**Re: Objection to MP08 0244 MOD 1 -
Modification Request for Mixed Used Development at 23-37 Lindfield Avenue
and 11 Havilah Lane, Lindfield**

FIGURE 1.4 – MODIFIED SCHEME RETAIL LEVEL

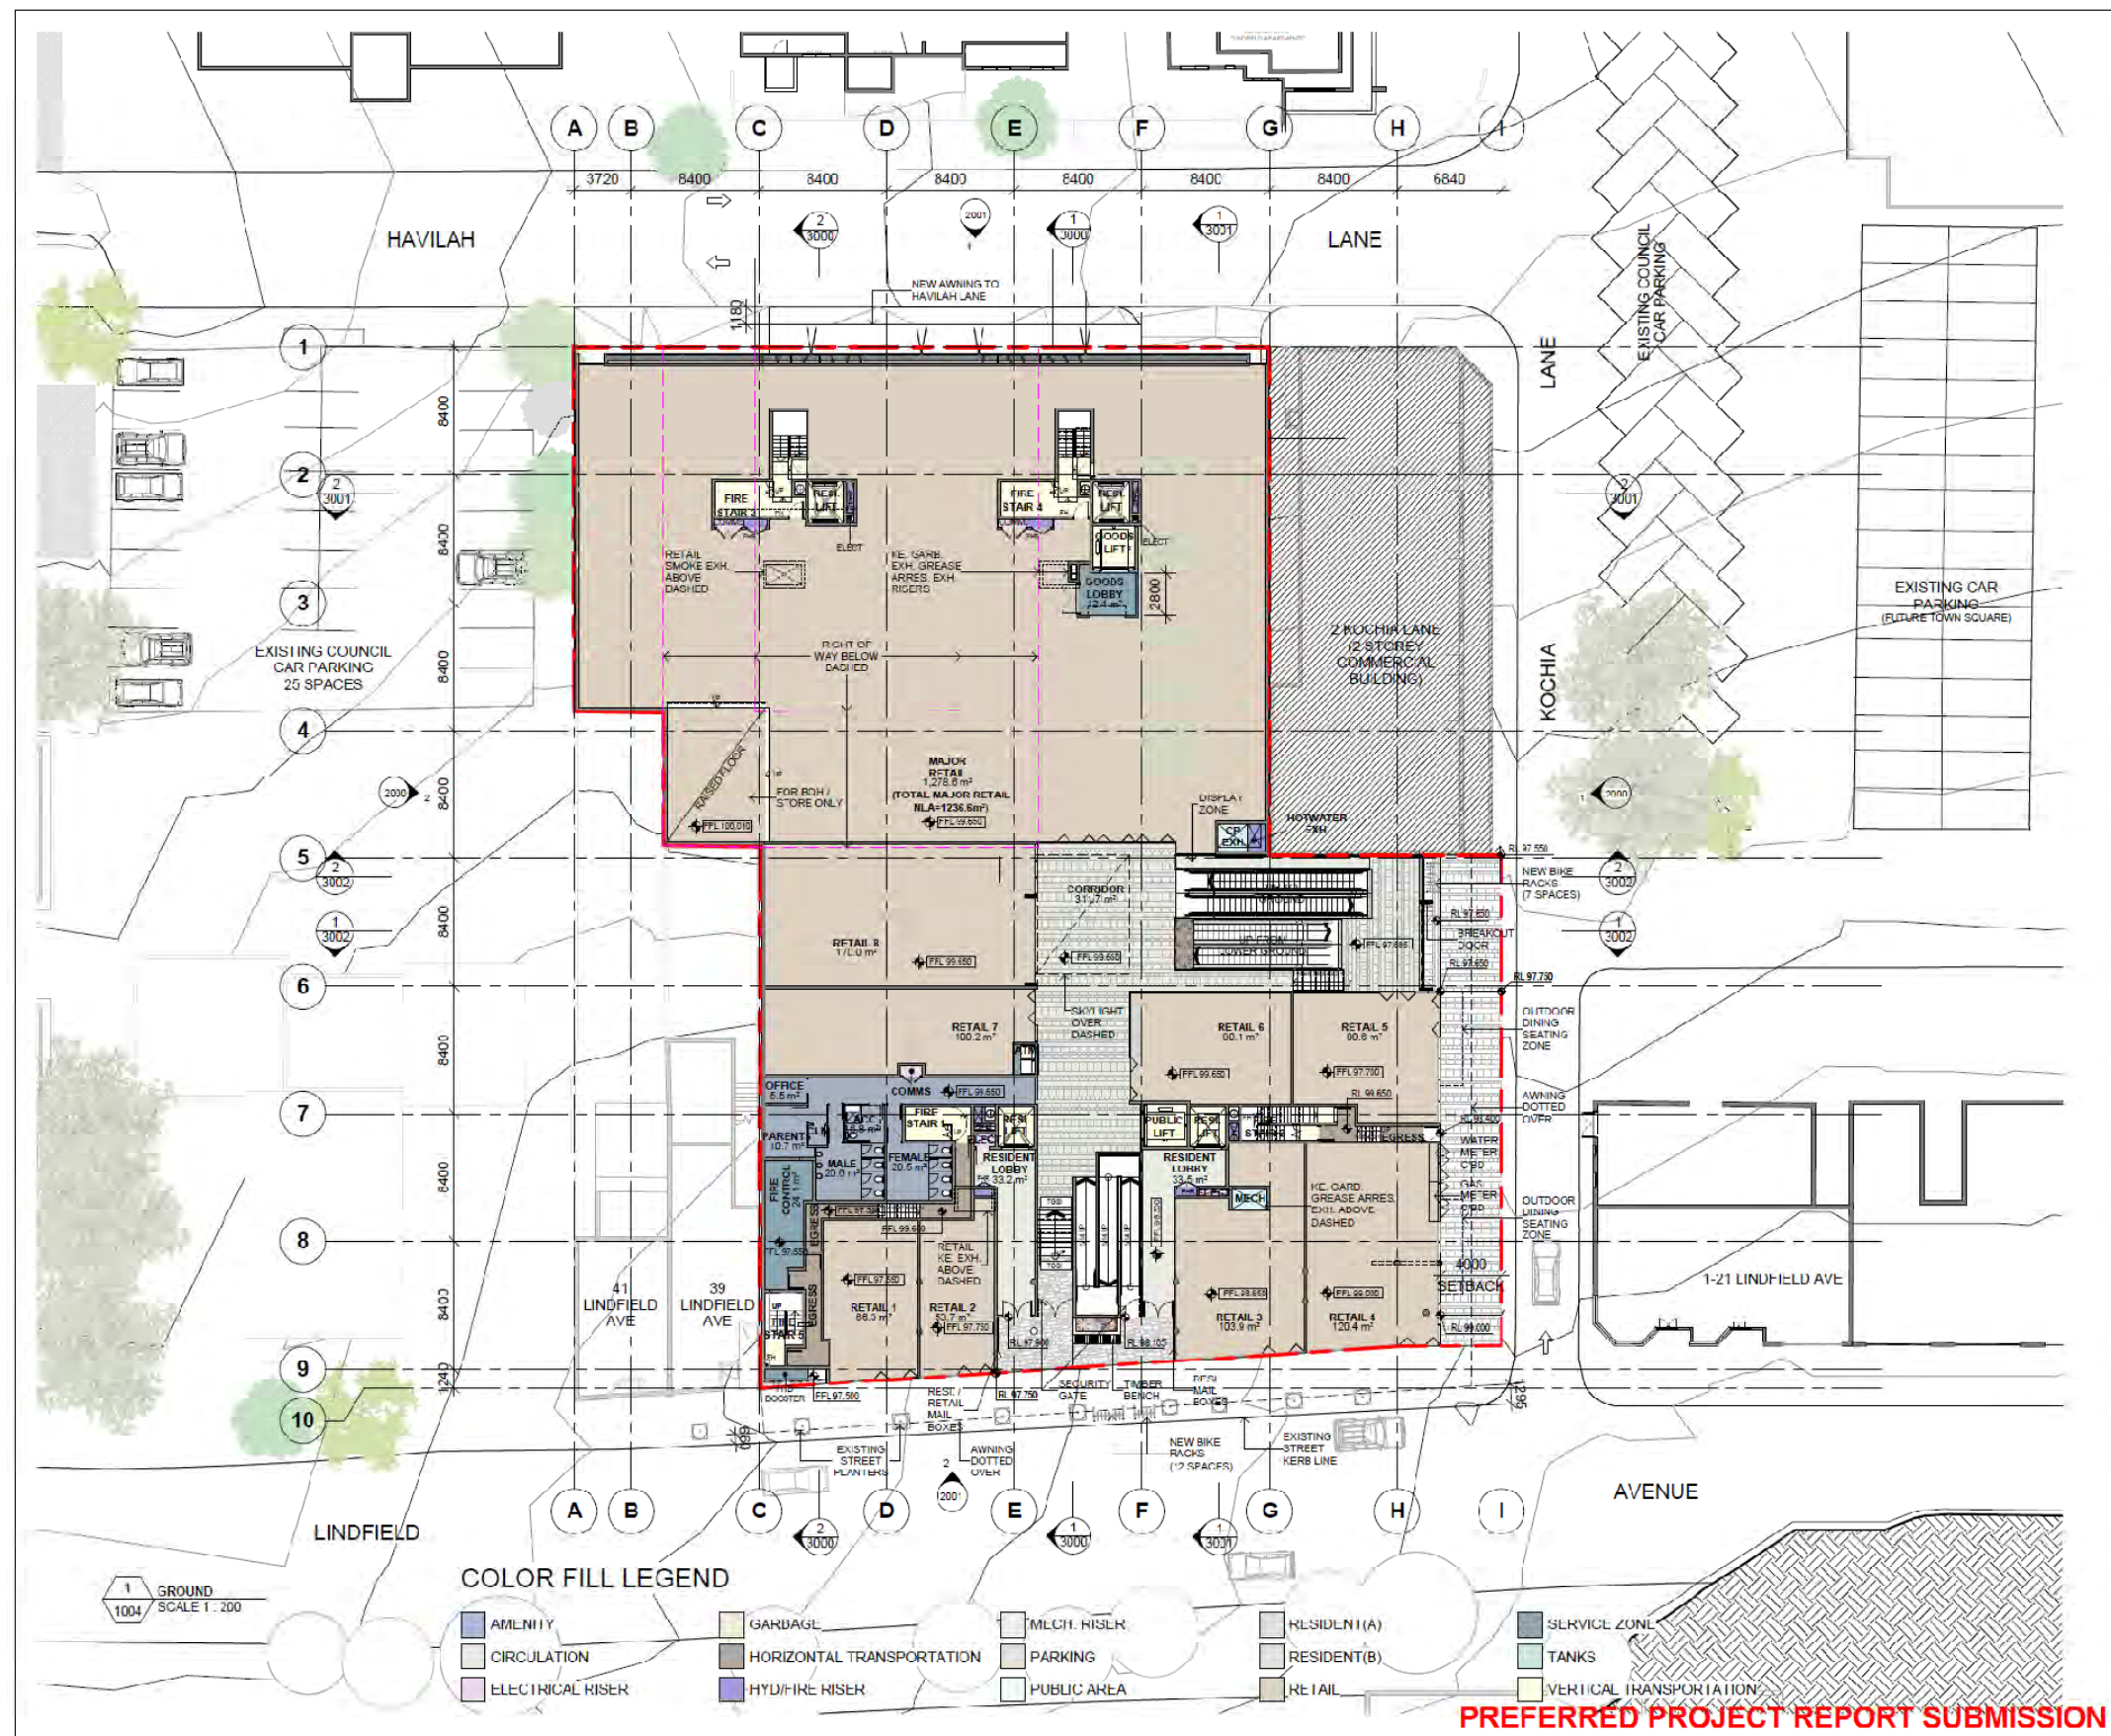
2. The proposed **reduction in overall retail space** within the two buildings in this development will disadvantage the wider community around Lindfield, not just those living in the immediate vicinity. The Lindfield shopping precinct is a vital hub not only for residents of houses/apartments in local areas but also – importantly, from a community perspective – for residents of a number of aged care establishments, who are bussed to Lindfield to do their weekly shopping (e.g. Lindfield Gardens at East Lindfield, Archbold House at Roseville, and Lourdes facilities at Killara). The further reduction of shopping amenities at Lindfield, as contained in the subject Modification, would **significantly disadvantage those who depend on Lindfield for their shopping amenities**.
